18 March 2019

Our Ref: 7484

**RE: Catherine McAuley Catholic College, 507 Medowie Road, Medowie
SSD 8989**

This letter provides a response to additional comments from government agencies in relation to the proposed Catholic College at Medowie. For clarity, comments from each agency are addressed separately.

Figure 19 | Car parking layout and bike parking spaces map (source: RtS 2019)

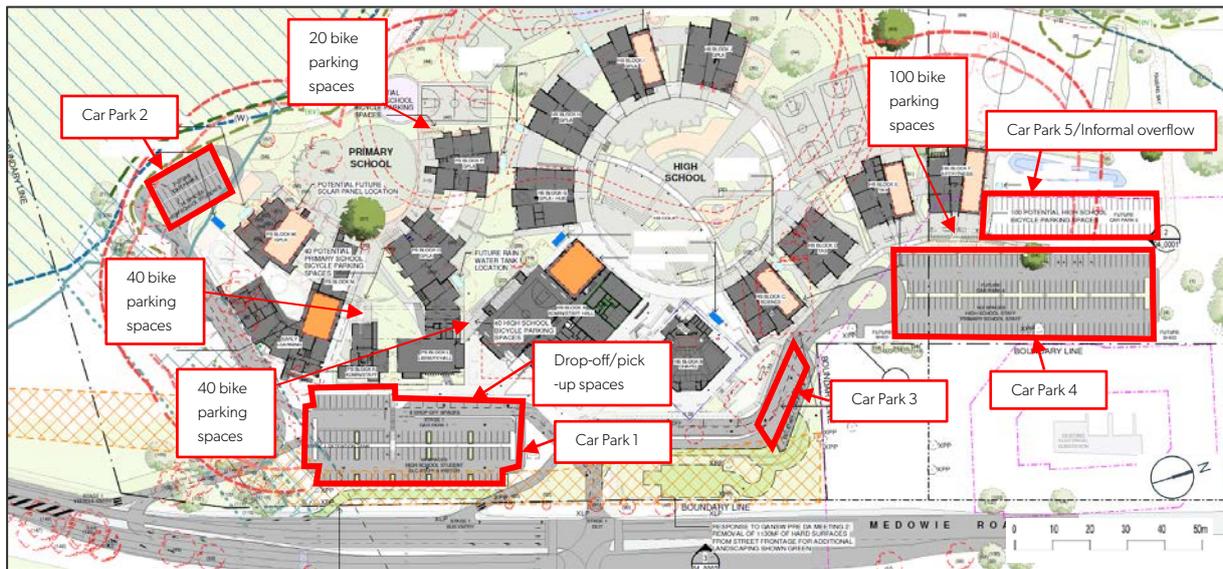
- Provide dispersed bicycle parking.

Response: Bicycle parking has been provided in a number of locations across the site. Refer drawing '2544_02_0002 Site Plan – Overall' which shows these locations.
